Subject: Building Permit # 2403-052
Date: Wednesday, June 5, 2024 at 7:25:51 AM Pacific Daylight Time
From: David Grubb <davidg@ghdarch.com>
To: Molly McGuire <molly.mcguire@mercerisland.gov>
Attachments: image001.png, image002.png, 2219 Seifert South Side Yard Grade.pdf

SEIFERT REMODEL
3261 67TH AVE SE
MERCER ISLAND, WA 98040

EXTERIOR ELEVATIONS
PROPOSED

2 SOUTH ELEVATION PROPOSED
SCALE: 1/4" = 1'-0"

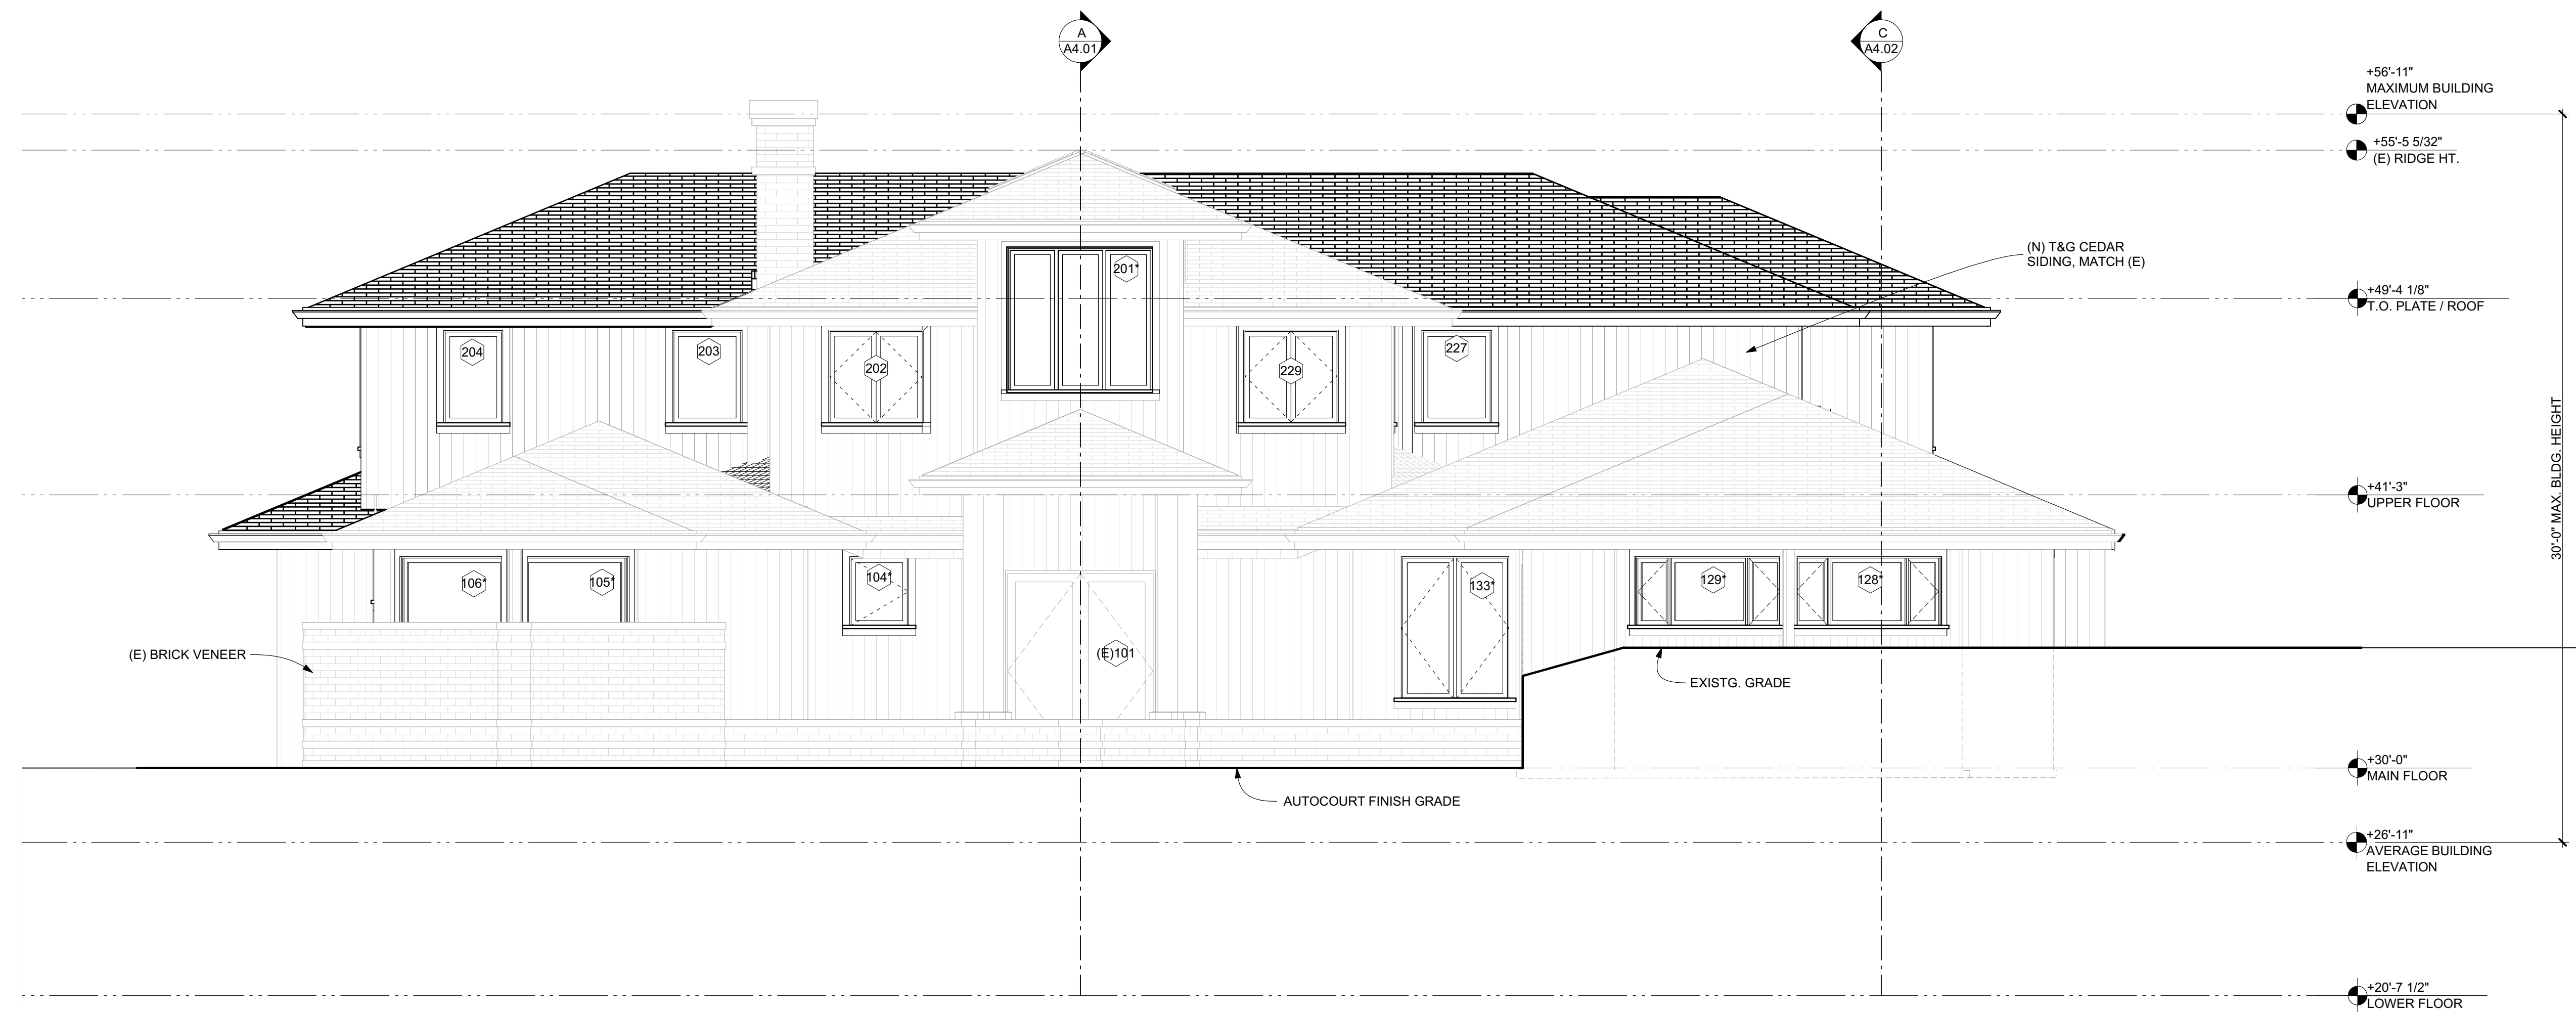
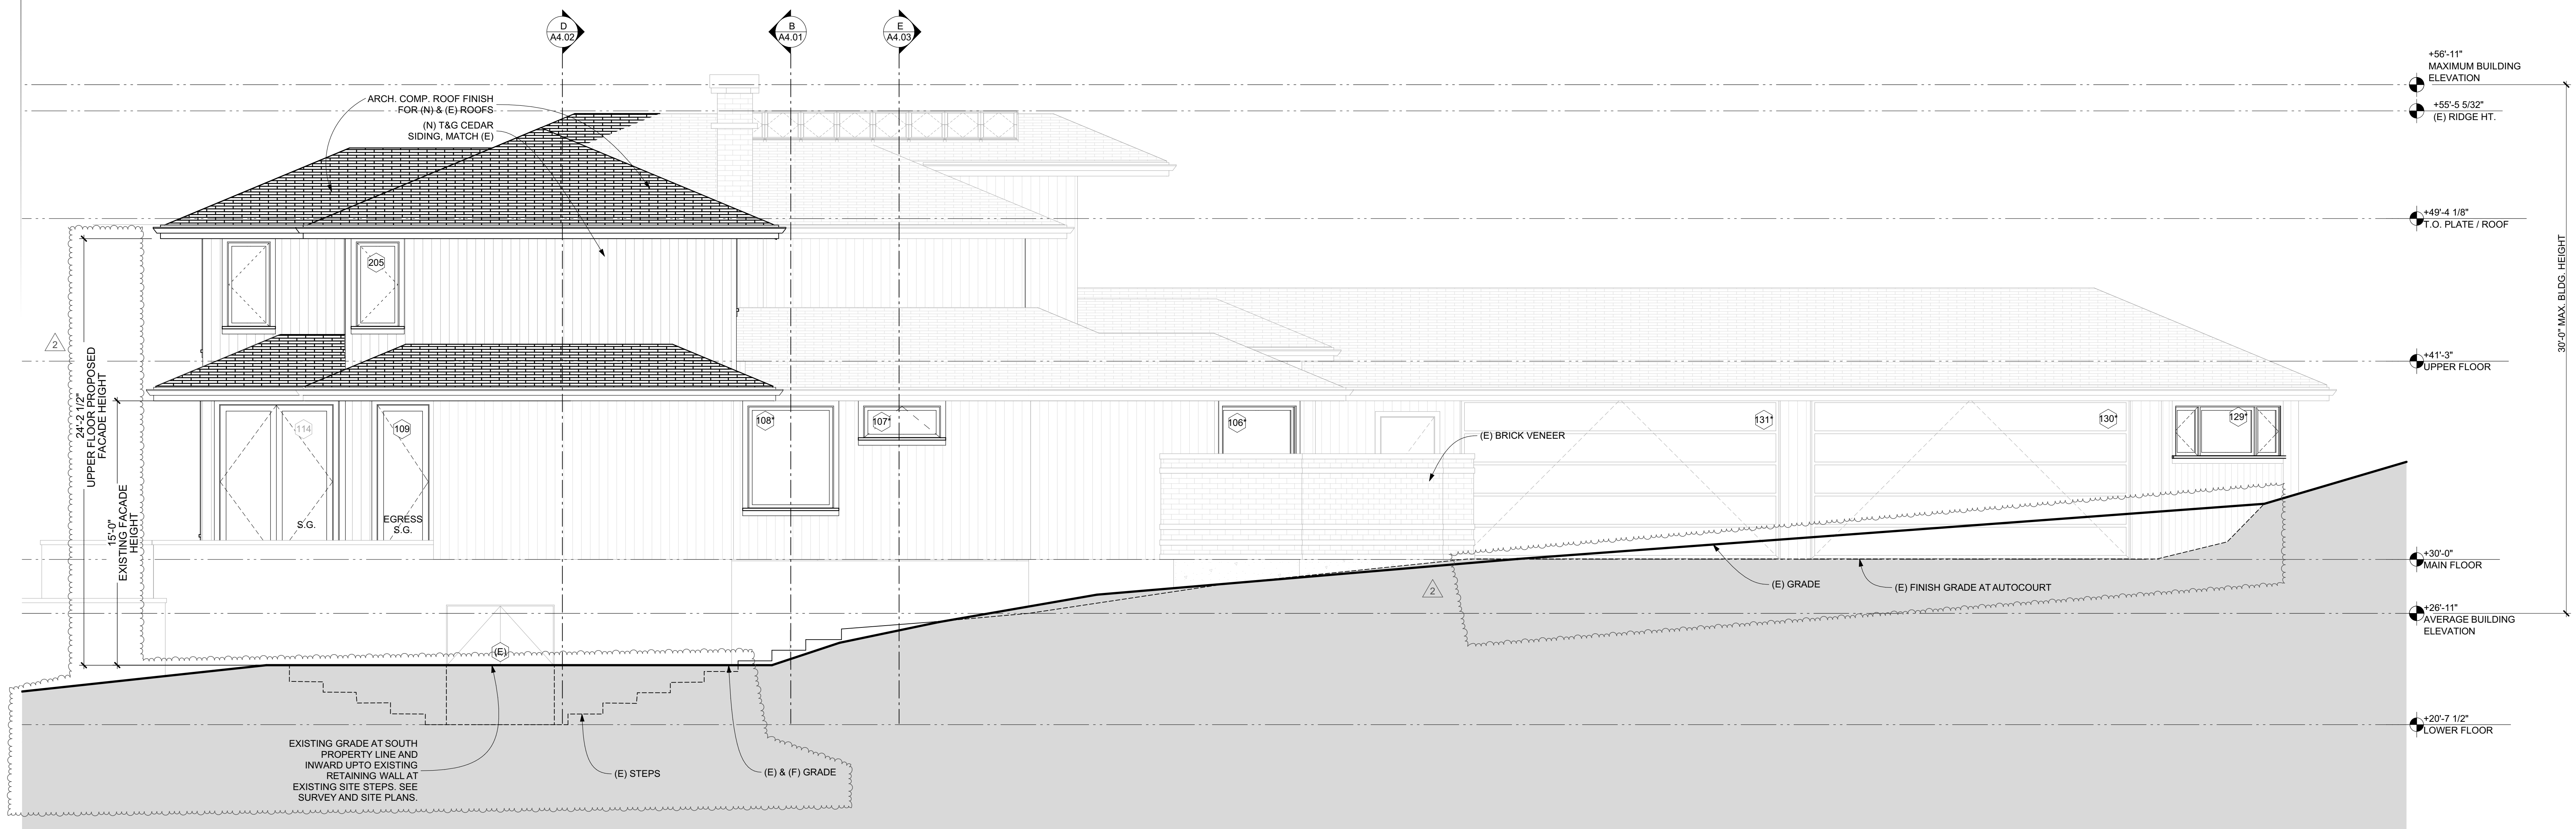
“Show existing and finished grades in relation to the basement on all elevation drawings to verify basement exclusion calculations.

See Appendix B for examples on how this should be shown in the drawings.”

“The wall facade abutting the south property line exceeds 25 feet in height and requires a 10 ft variable side yard setback per MICC 19.02.020(C)(1)(c)(iii)(b):

Single-family dwellings with a height of more than 25 feet measured from the existing or finished grade, whichever is lower, to the top of the exterior wall facade adjoining the side yard shall provide a minimum side yard depth of ten feet.

Additions in height are required to comply with all residential development standards, including all required yard setbacks. The upper story addition in this area results in an addition in height, which would require compliance with the variable side yard setback per MICC 19.01.050(D)(1)(b)(i):

...An increase in height of that portion of a structure that is legally nonconforming because it intrudes into a required yard is an increase in the nonconformity and is not allowed unless the additional height meets the current yard requirements of MICC 19.02.020(C)(1)

Because the lower portion requires a 7.5 ft side yard setback per MICC 19.02.020(C)(1)(c)(iii)(a)(1), this portion is nonconforming.”

We revised the south exterior elevation to reflect the existing/final grade a little more accurately per comment #1 above. Meaning that we are showing grading not only directly against the exterior wall, but also just inward of the south property line to show true conditions. Please see attached pdf with a current survey (showing the updated accuracy per your request) that I highlighted this area being discussed. You can see how much higher the grade is at the south property line, adjoining southern property, and the timber wall that is retaining grade in this area, allowing for access to the crawl space. Also included in the pdf is revised south elevation showing existing and final grade at both the timber steps/double doors for access (per originally submitted elevation) and grade directly behind timber retaining wall/in front of the south property line.

Regarding comment #2 above: If we scale the façade height from grade that is at the south property line/directly behind the timber retaining wall it is 25' or less along the proposed upper floor exterior wall. We understand the intent of the code is to protect neighboring properties with views and massing close to property lines. As explained above, the façade height that you measured was taken from a dug out access point for crawl space. Please let me know if this is an acceptable means to comply with the side yard setback code requirement. Regarding the main floor exterior façade height. We are not proposing any increase in height to the existing main floor exterior wall/plate heights. We are simply removing the

necessary portions of the existing roof structure to allow of the new upper floor addition and reroofing all existing roof areas that remain.
